**STORM WATER MANAGEMENT PLAN
FOR
A-1 CHIPSEAL
7245 COLE VIEW, COLORADO SPRINGS**

JULY 2022

County Job No. COM-22-014

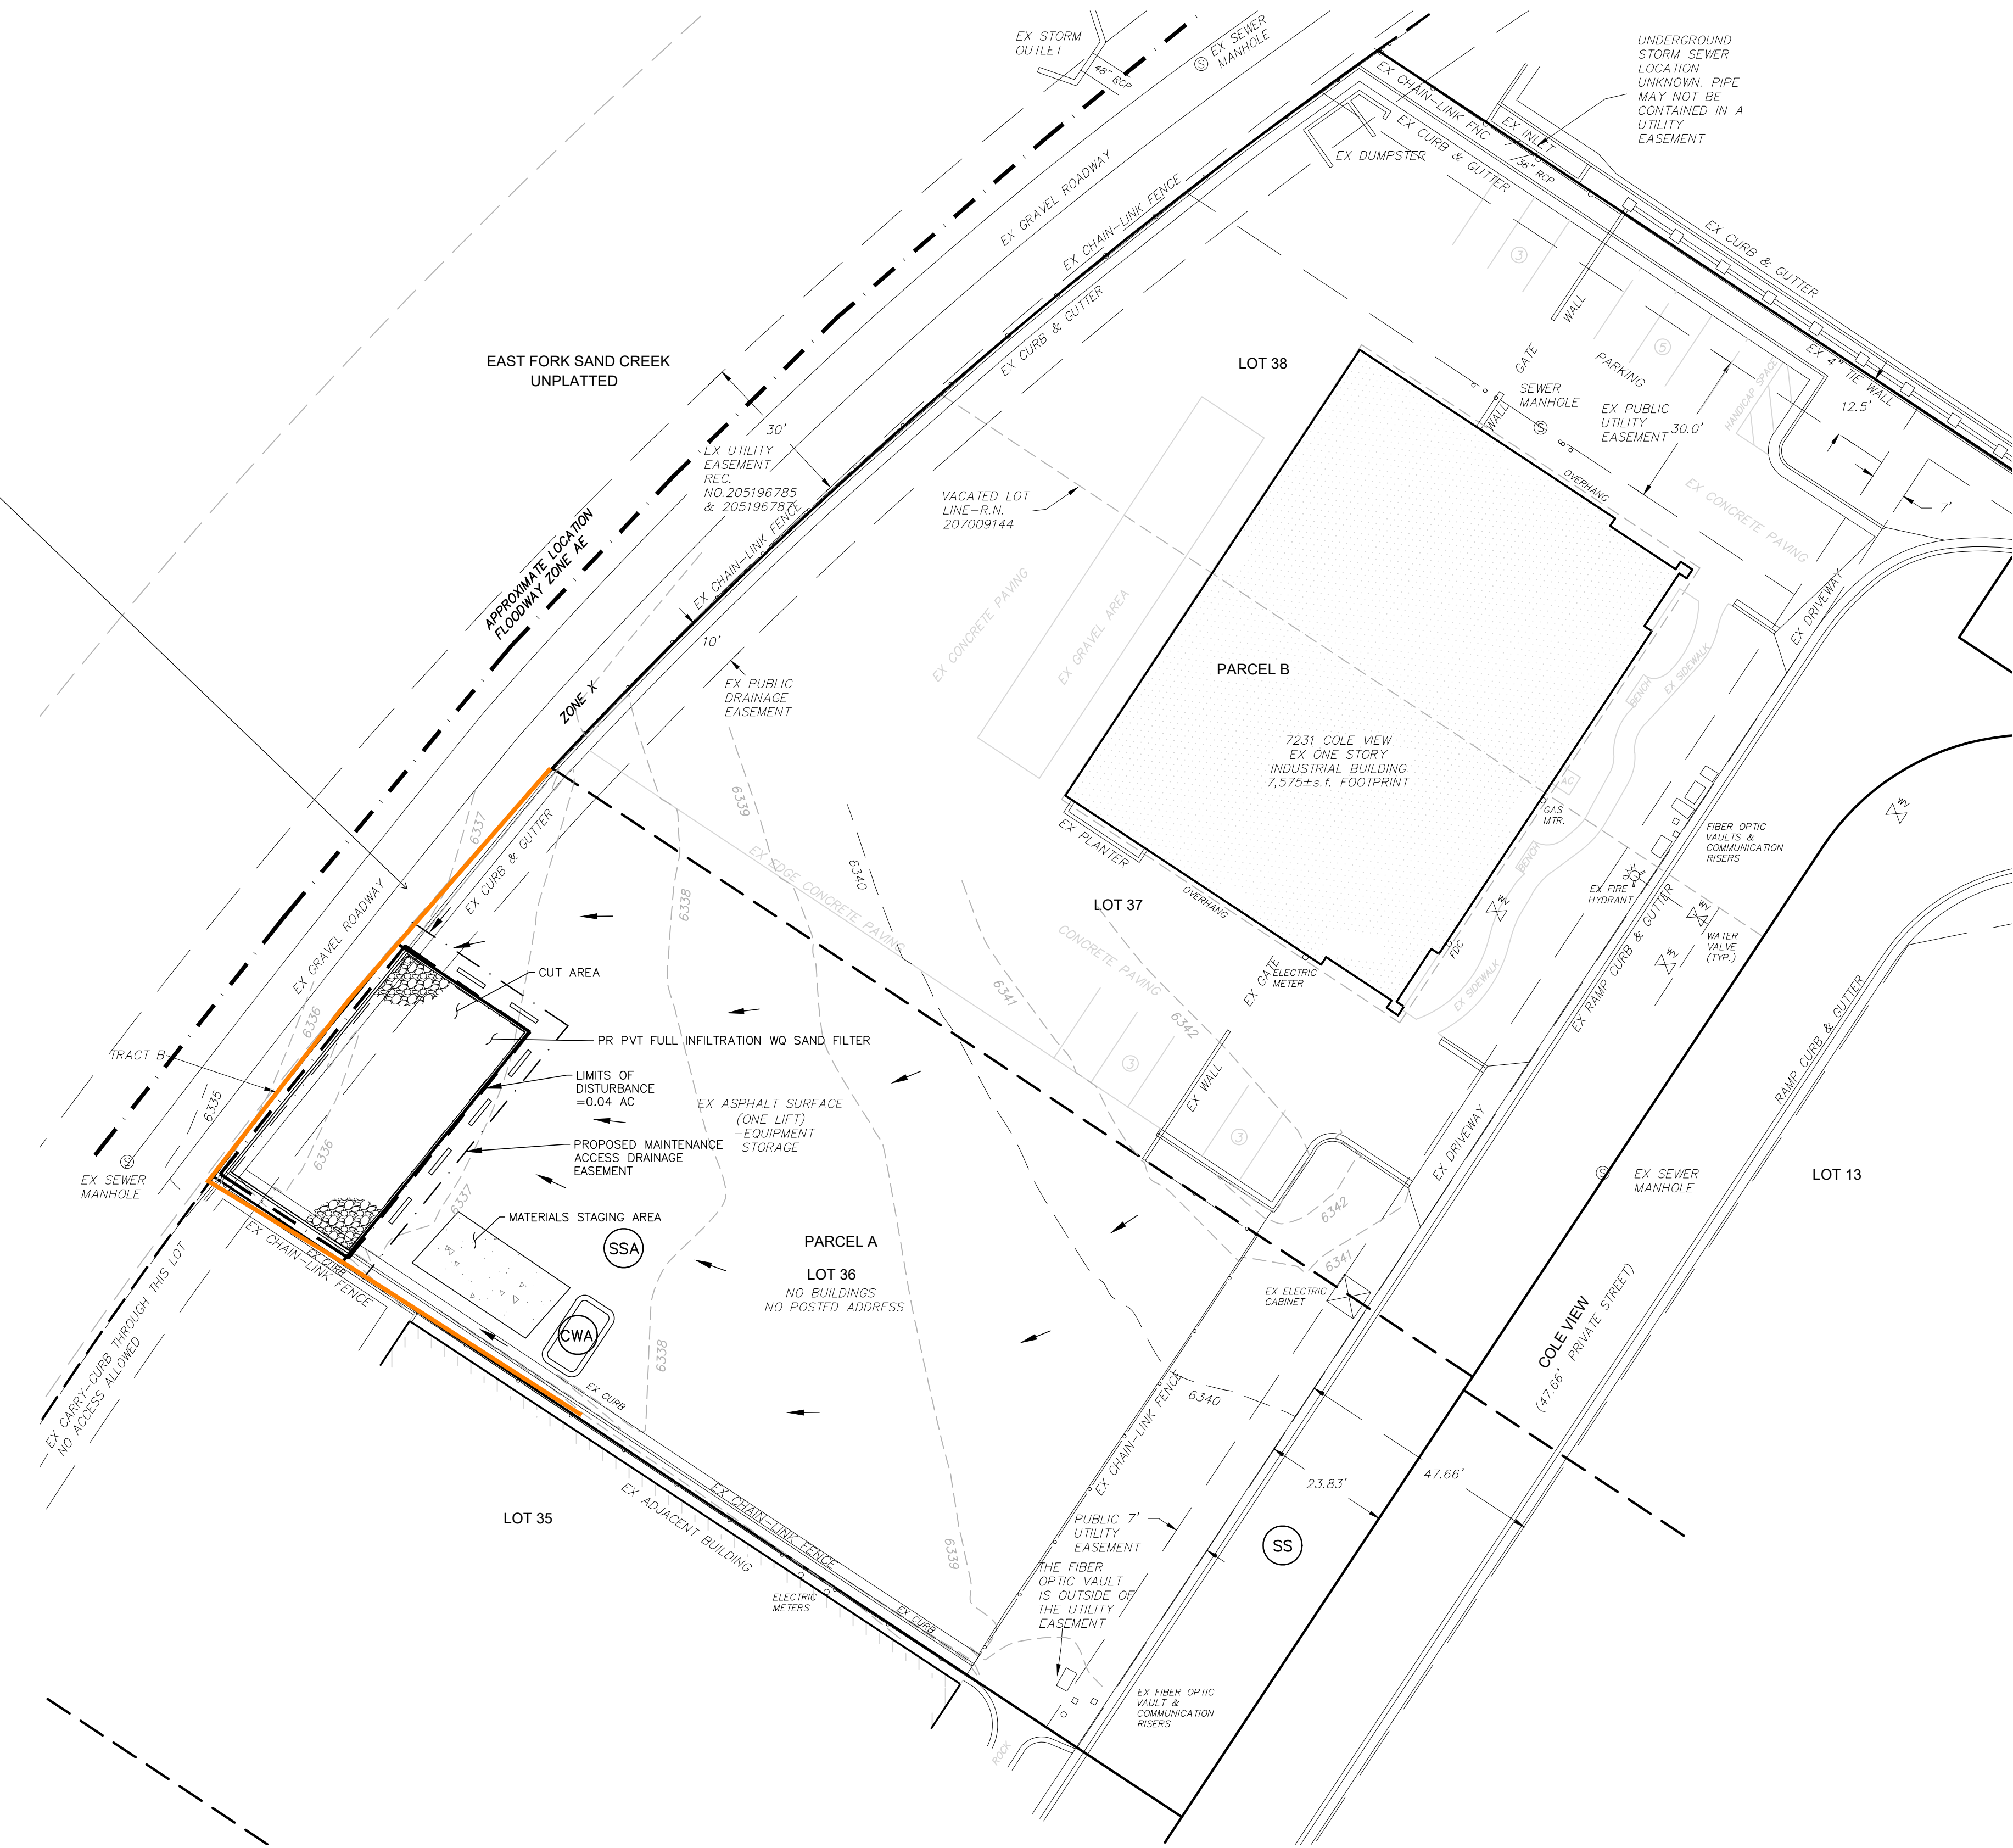
Please include perimeter controls (i.e., silt fence). See GEC comments for locations.
Unresolved.
